From: Geoff Thorpe <[REDACTED]>
Sent: 27 June 2019 10:59
To: Planning
Subject: Applications AB/48/19/PL and AB/49/19/L - for the attention of Mrs Gardner

Having read Martyn White's planning response to the above applications, posted on the Arun planning portal, please can I, on behalf of the applicant confirm/ advise as follows:

A6001-03
1 : 100 @ A2
29.04.19

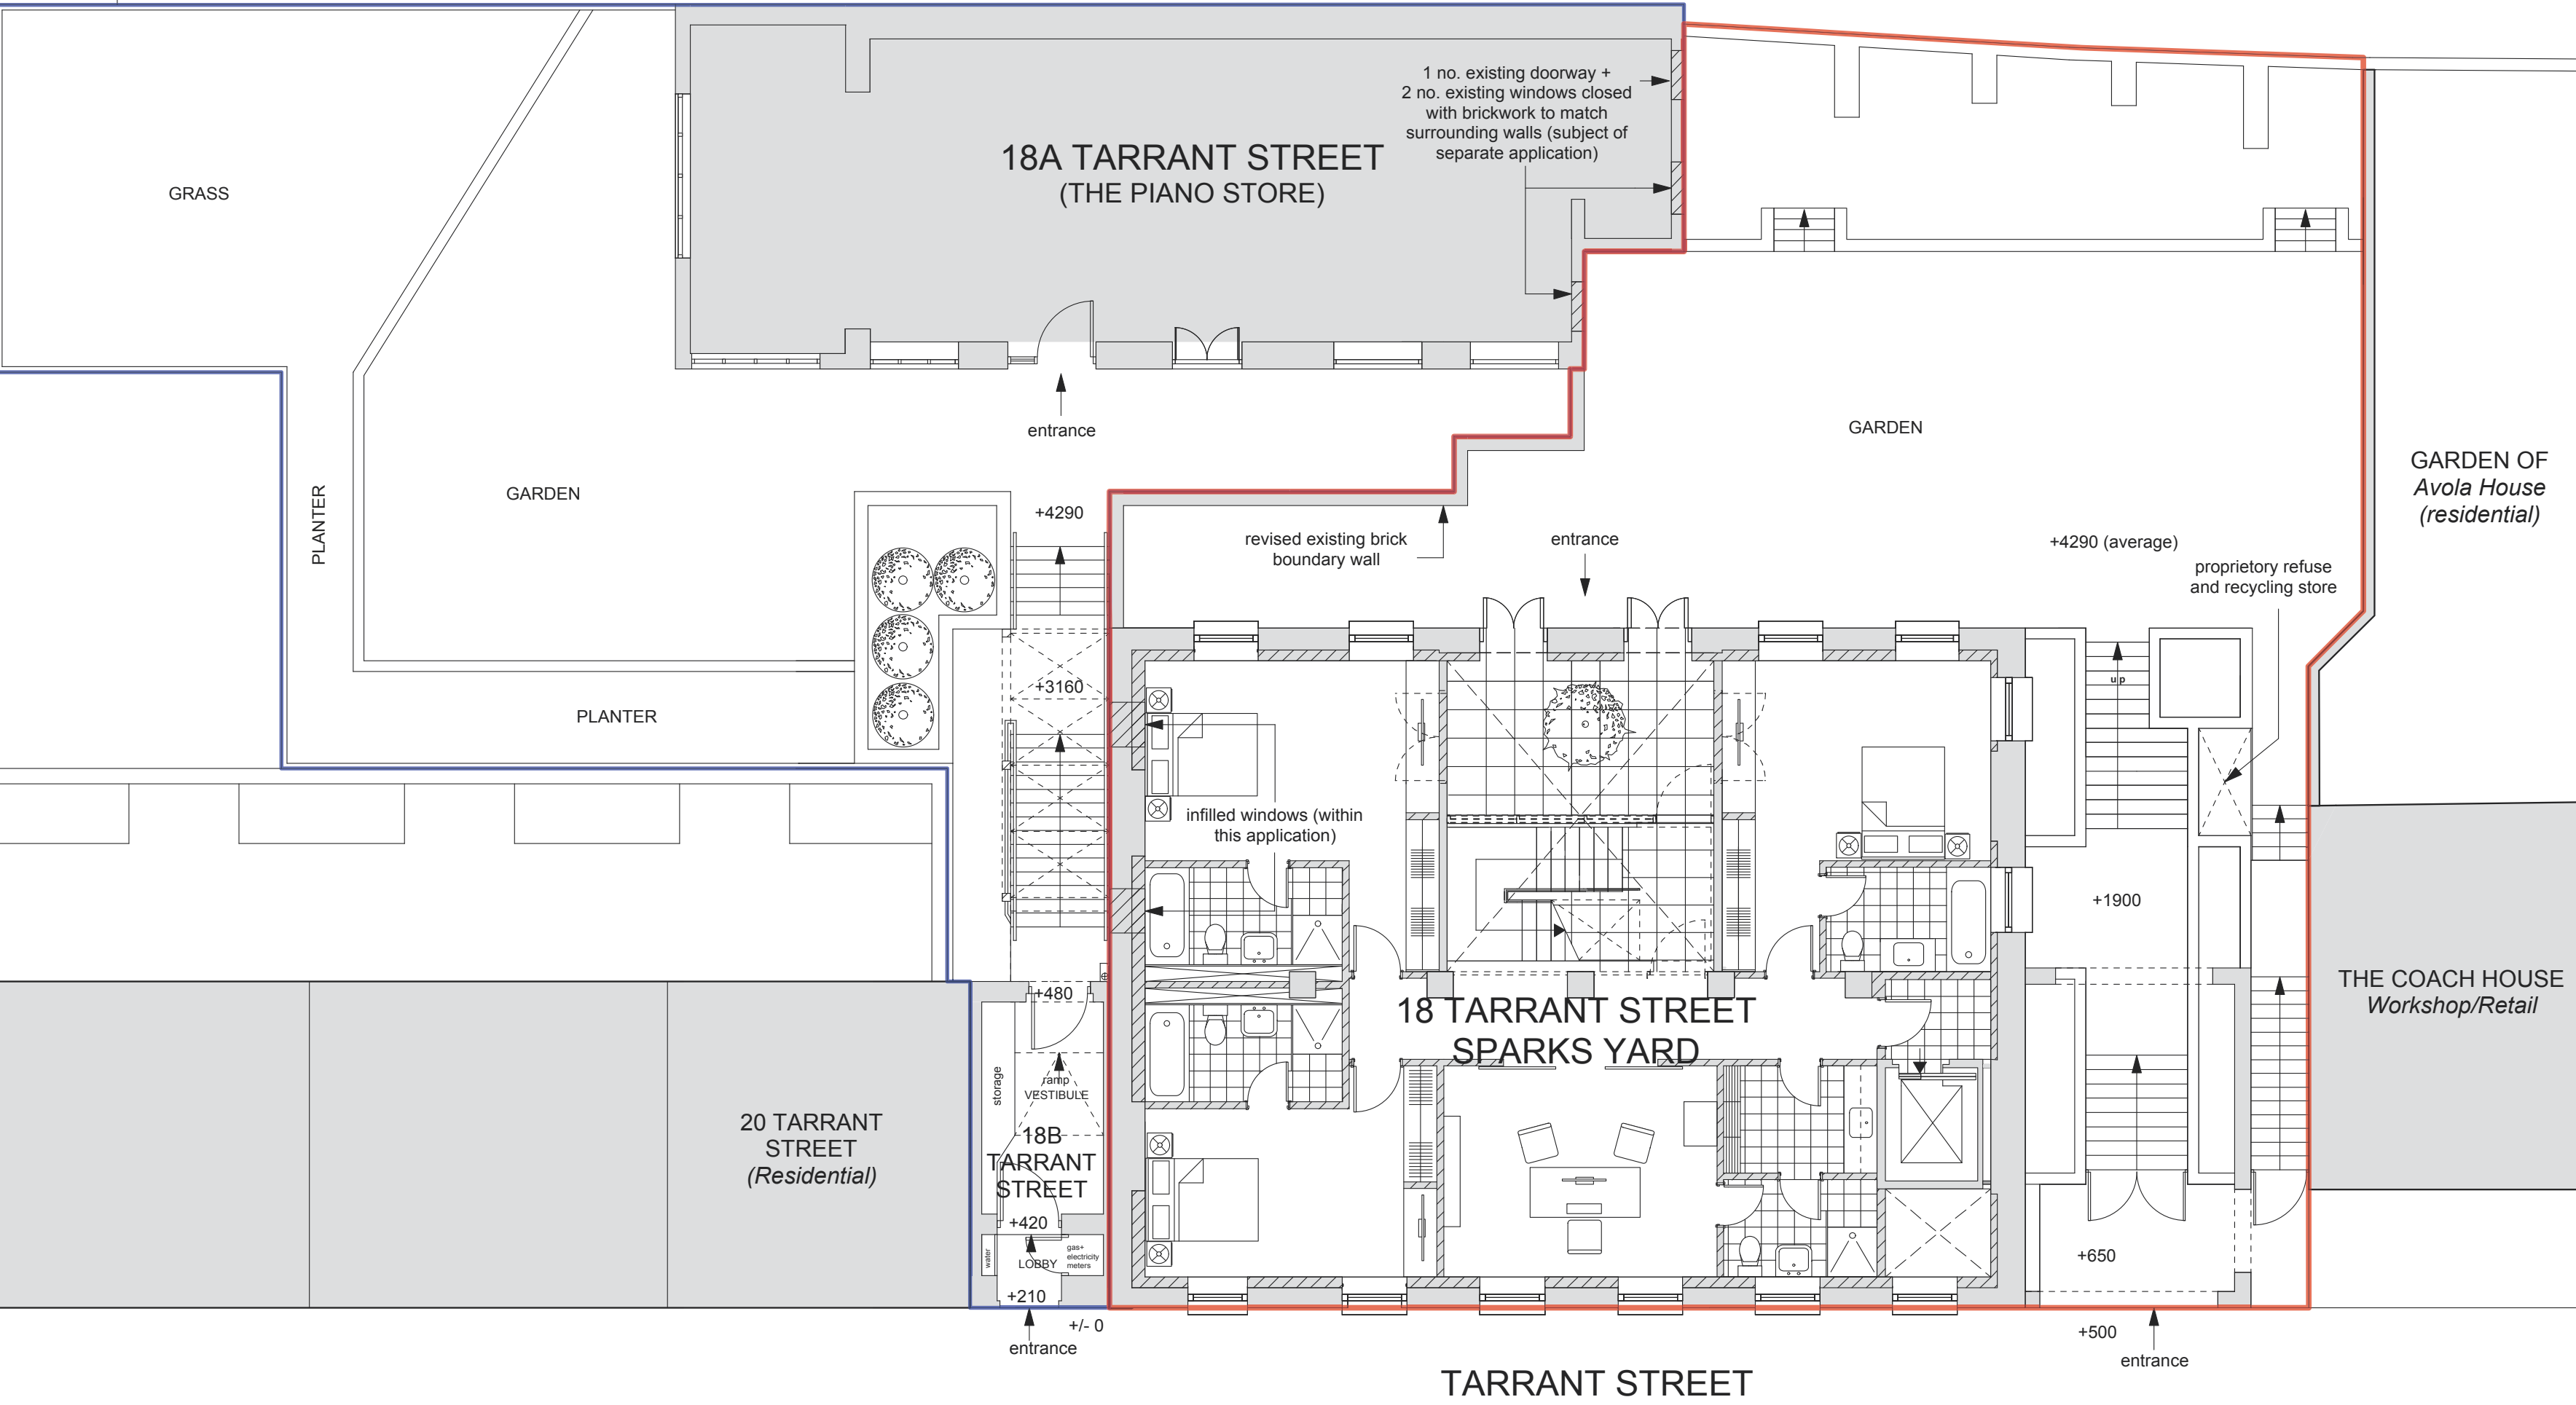
5. My apologies. Looking at the drawings as submitted, it is not at all clear exactly what the 'revised existing brickwork wall' noted in drawing A6001-03 actually is! Our other application in respect of the adjacent property [AB/50/19/PL] is much clearer, but for some unknown reason we did not include this information in the submitted drawings for these applications. We are currently revising drawing A6001-03 to include this information and intend submitting it to you as amended drawing no. A6001-03 revision A, later today.

A6001-08

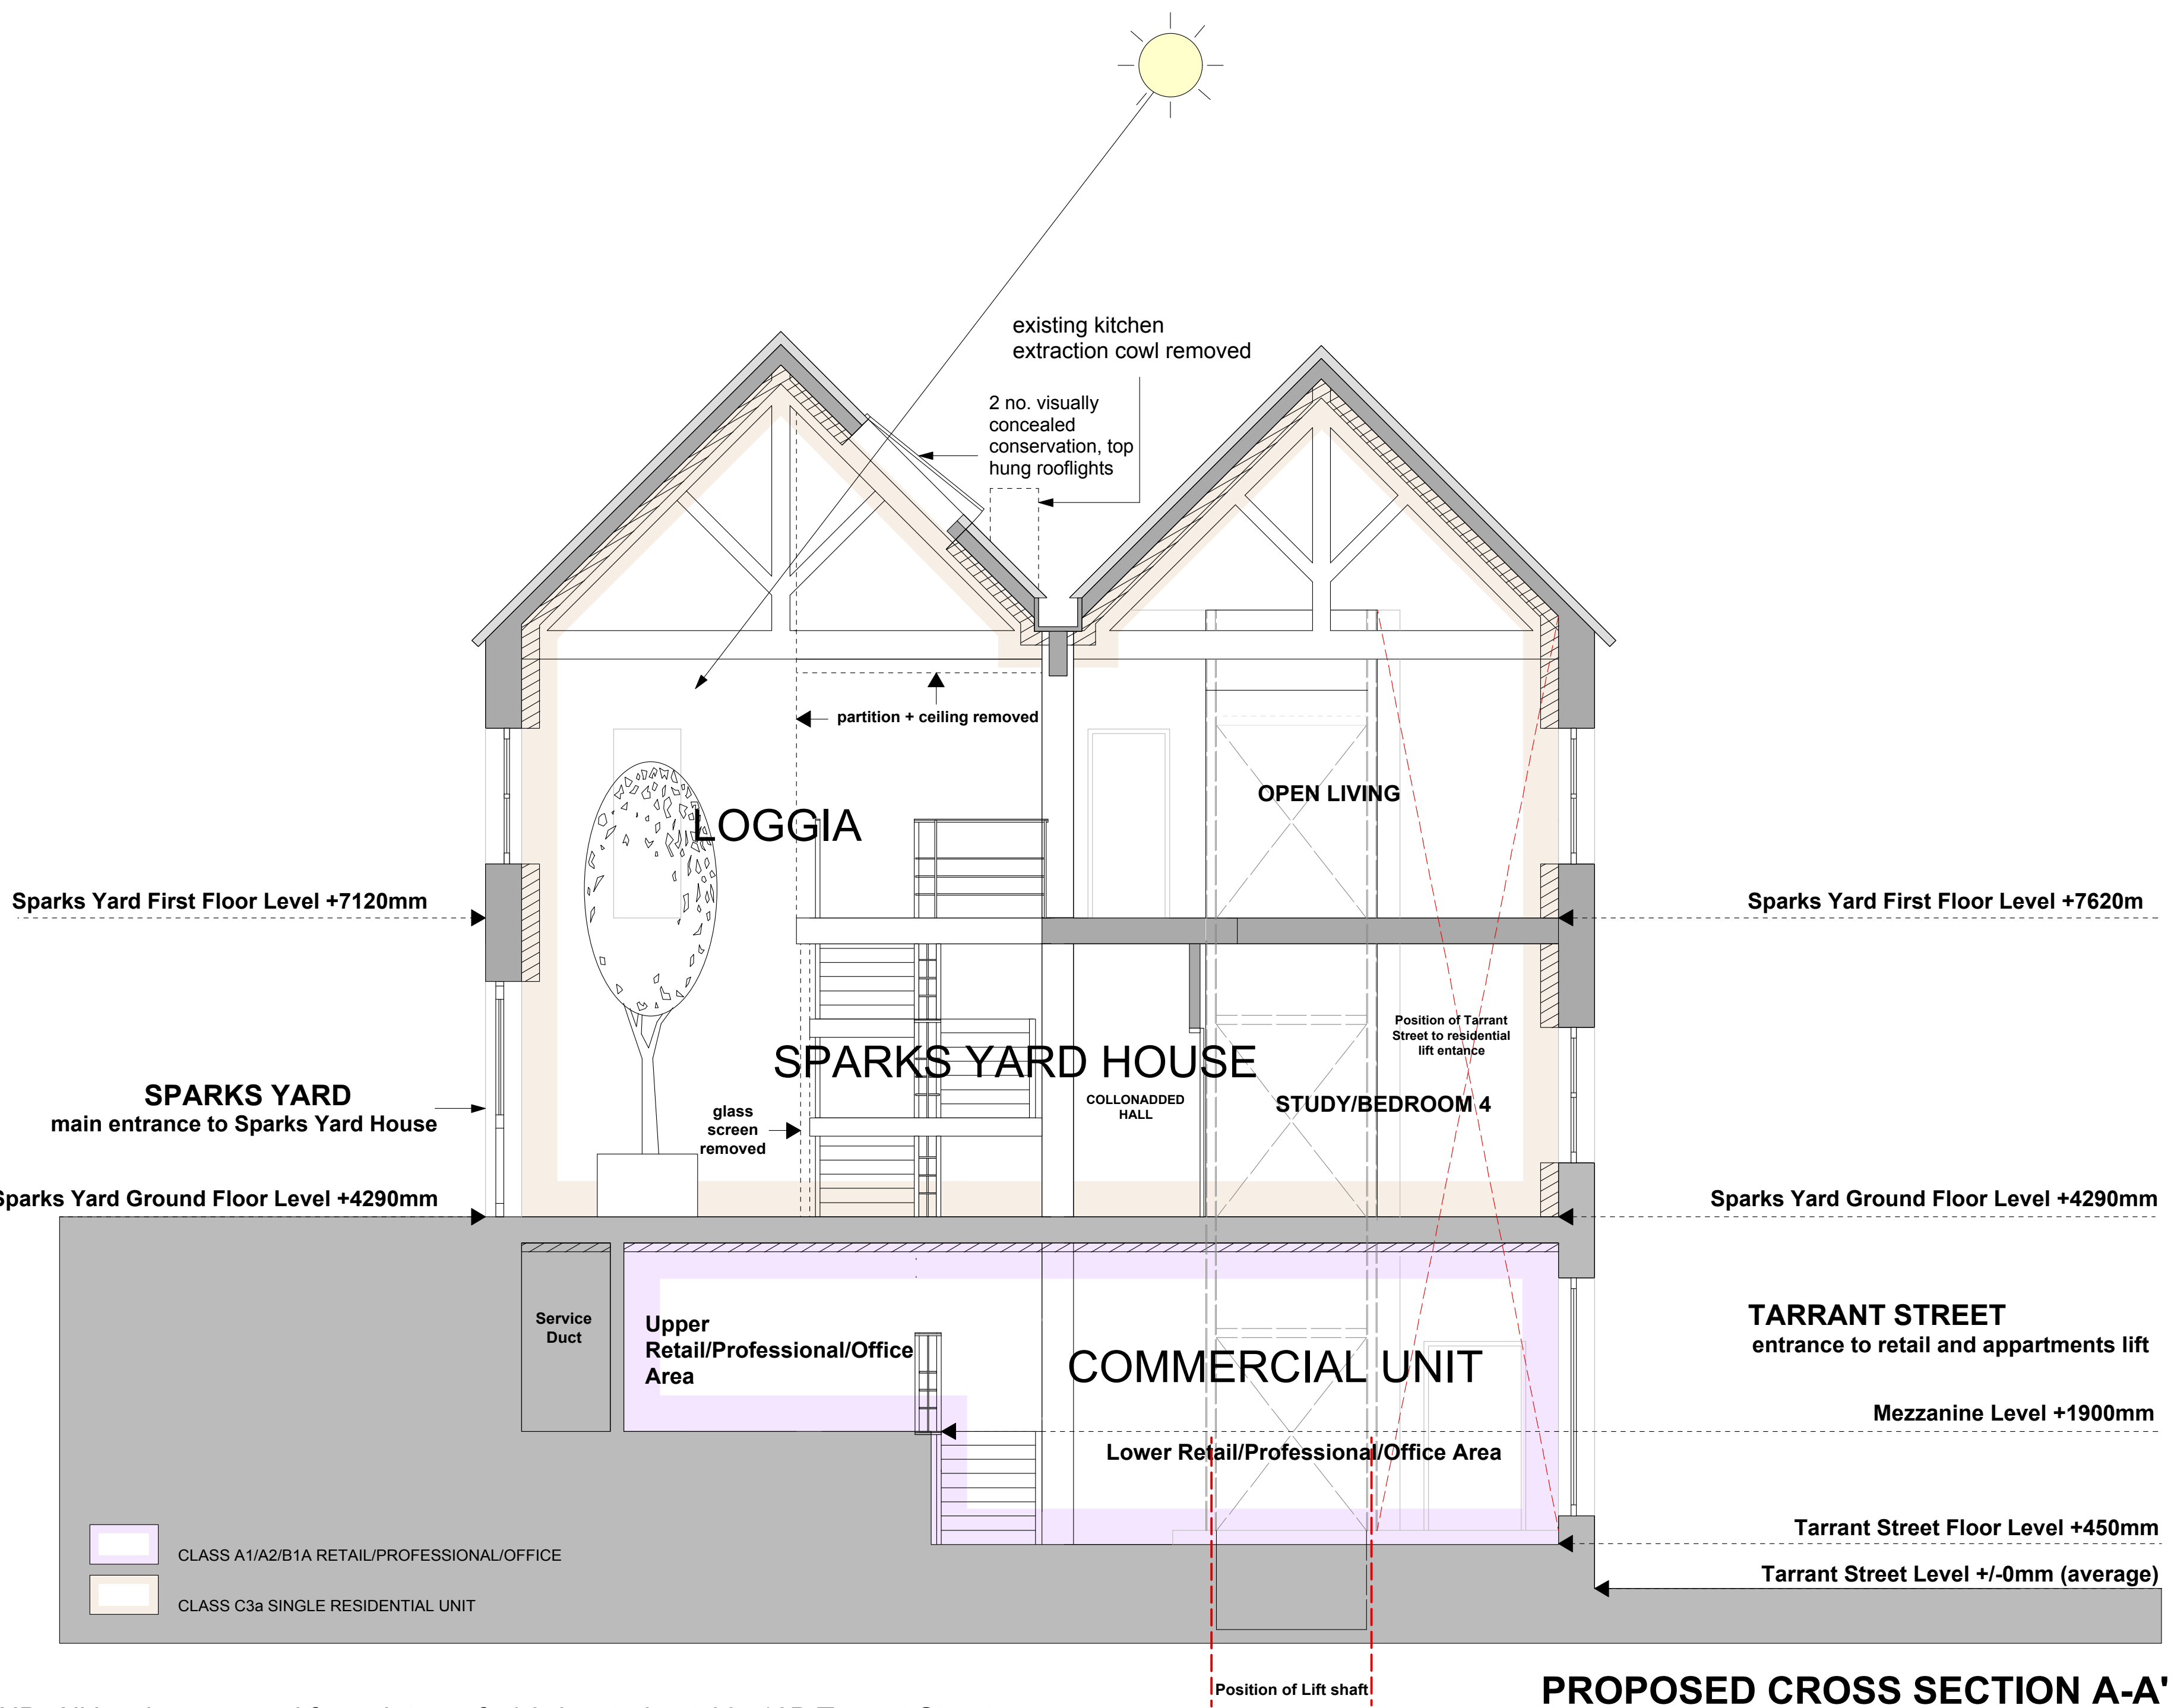
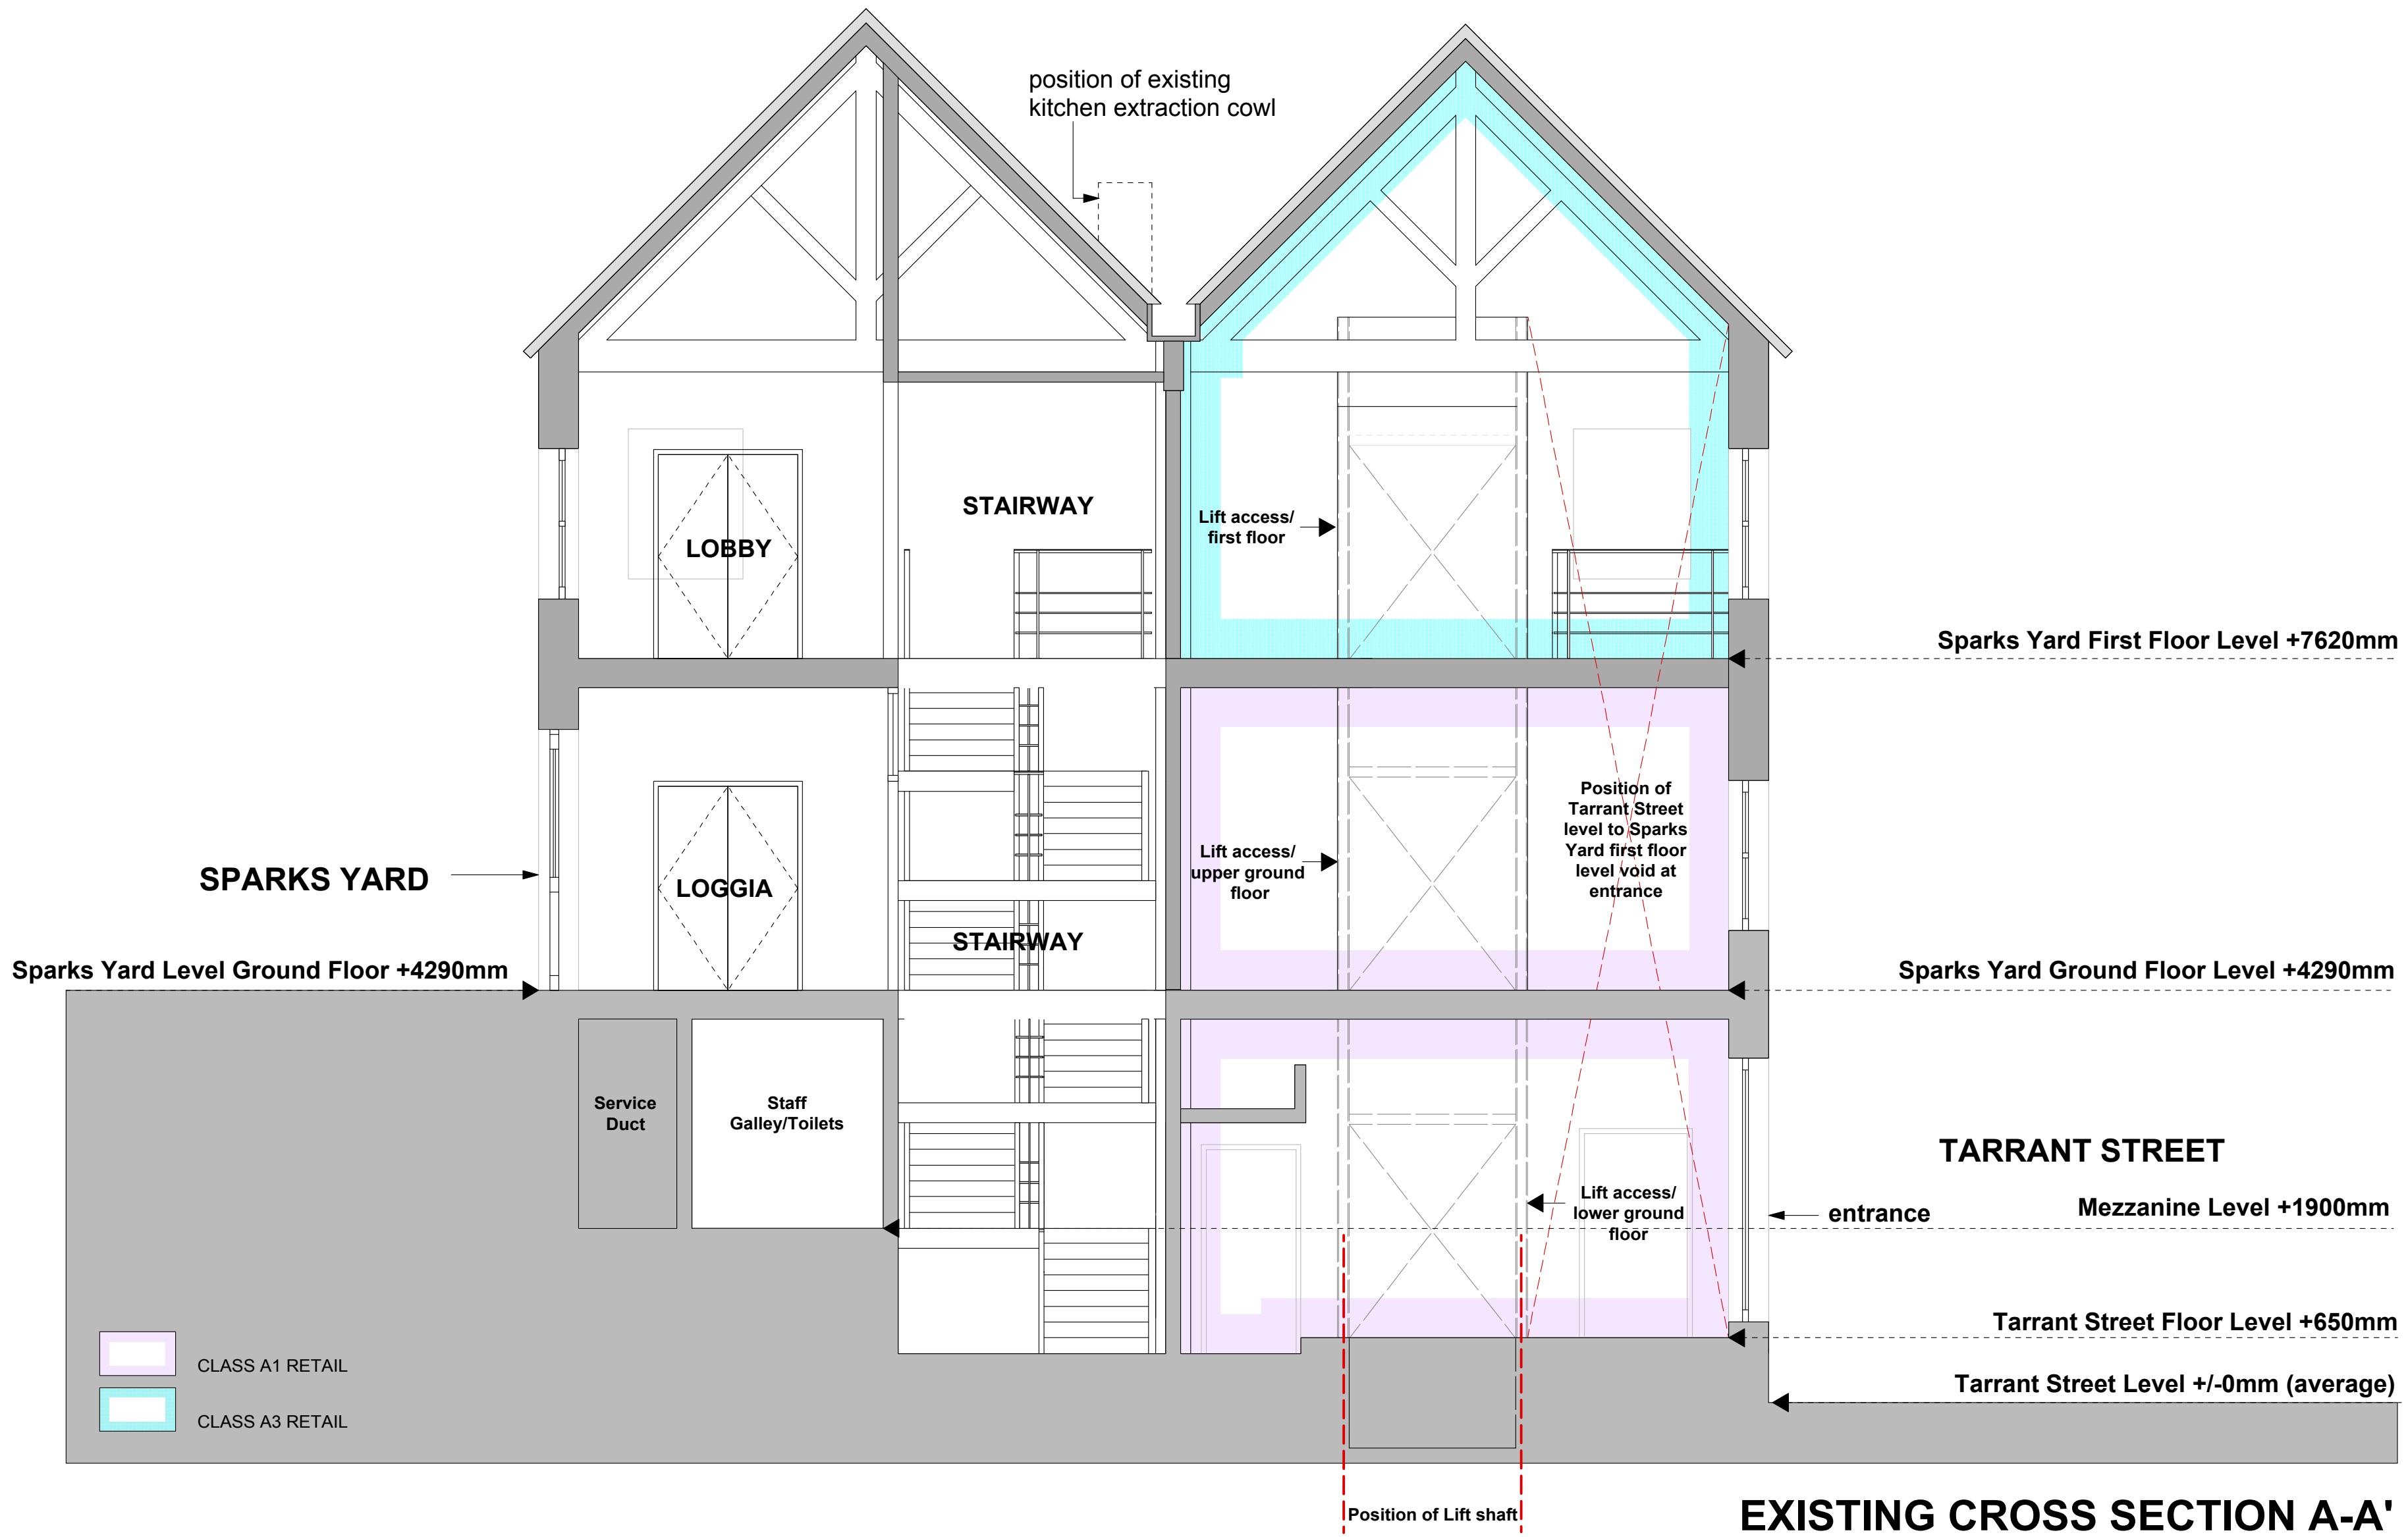
2. I am delighted to read the concerns relating to the lining of the external brick walls with insulation and plasterboard. We do not wish to do this and it was only included in the proposal in order to satisfy the inevitable thermal insulation requirements of building regulation approval. I confirm therefore that we wish to amend our applications in order to remove all proposed external wall linings to the upper two floors of the buildings and will seek an agreement to relaxation when the building regulation approval

application is made, citing its unacceptability for inclusion within this listed building. Would you like us to submit amended drawings to cover this or can this be covered by a potential condition?
